**KIRKLEES METROPOLITAN COUNCIL
DEVELOPMENT & MASTER PLANNING SERVICE**

**DELEGATED DECISION FOR PRIOR APPROVAL FOR CHANGE OF USE
FROM COMMERCIAL, BUSINESS AND SERVICE USES TO
DWELLINGHOUSES**

Reference no. 2022/CL/93522/W

Site Address	first floor, 27, Market Street, Milnsbridge, Huddersfield, HD3 4ND
---------------------	---

Drawing Title
 First Floor Plan

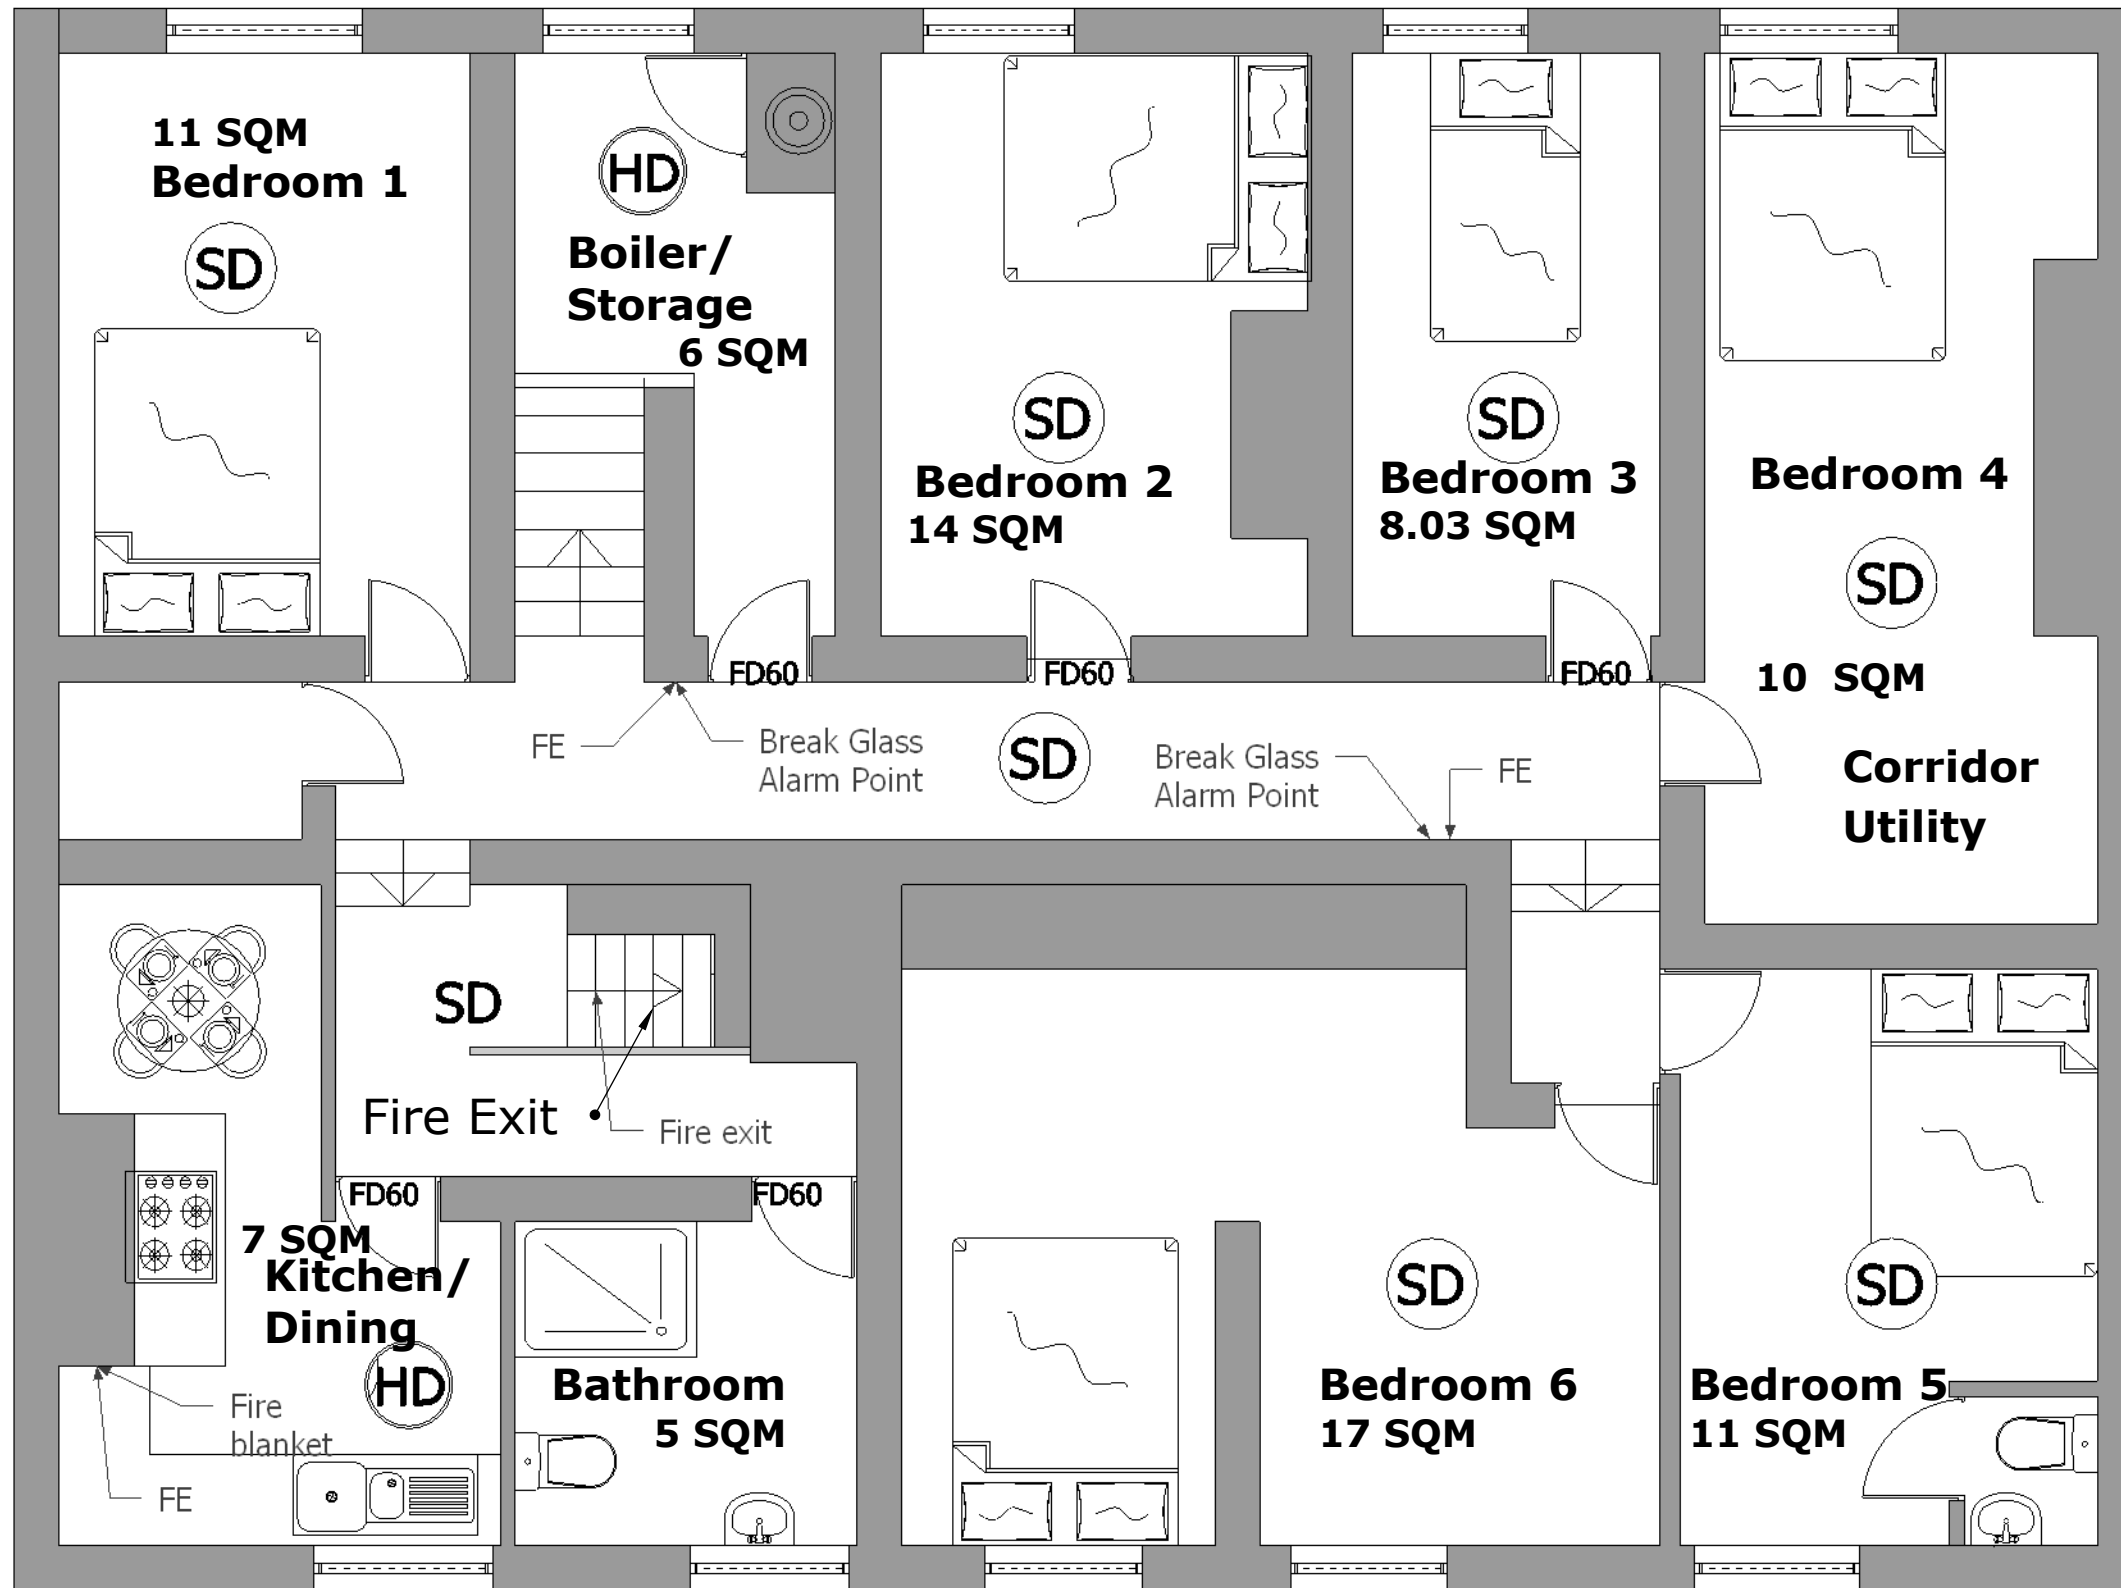
In this instance, the accommodation proposed would be over one storey and would be a 6 no. bedroom property with a shared kitchen and bathroom. The Technical Housing Standards document states that a single storey property with 6 no. bedrooms should be a minimum of 116 square metres based on 7 bedspaces and 125 square metres based upon 8 people sharing the property. In this instance while the internal layout indicates the size of each room the Gross Floor Area as defined by the Technical Space Standard is unclear as the scale is incorrect. The Gross Floor Area is the internal floor as when measured from the perimeter walls of the dwelling. In this case the red line boundary shown on the location plan appears to be consistent with the Council's mapping system and while of a large scale the maximum area the dwellinghouse could be is 120 sq metres externally. As the floor plans indicate 11 bedspaces the minimum space is 125 sq metres.

In addition, the technical requirements state that in order to provide 1 bedspace would require a floor area of at least 7.5 square metres a double or twin bedroom for 2 bedspaces would require a floor area of at least 11.5 square metres. The submitted information indicates that 1 no. single bedroom would be created which would meet the standards (bedroom 3) and 5 no.

double bedrooms are proposed of which 3 of the bedrooms (bedrooms 1, 4 and 5) which would fail to meet the required.

Therefore, in total, the building falls short of the recommended space standard and therefore cannot benefit from prior approval.

In terms of natural light, the property hosts openings within the front and rear elevation and it is indicated on plan that each bedroom and the kitchen and bathroom host one window per room. This would provide natural light into the property to a reasonable standard.

It is considered the internal gross floor space of the dwellinghouse does not meet the space standards for the 11 bed spaces proposed.

The submitted information also indicates that 1 no. single bedroom would be created which would meet the standards (bedroom 3) and 5 no. double bedrooms are proposed of which 3 of the bedrooms (bedrooms 1, 4 and 5) which would fail to meet the required space standards.
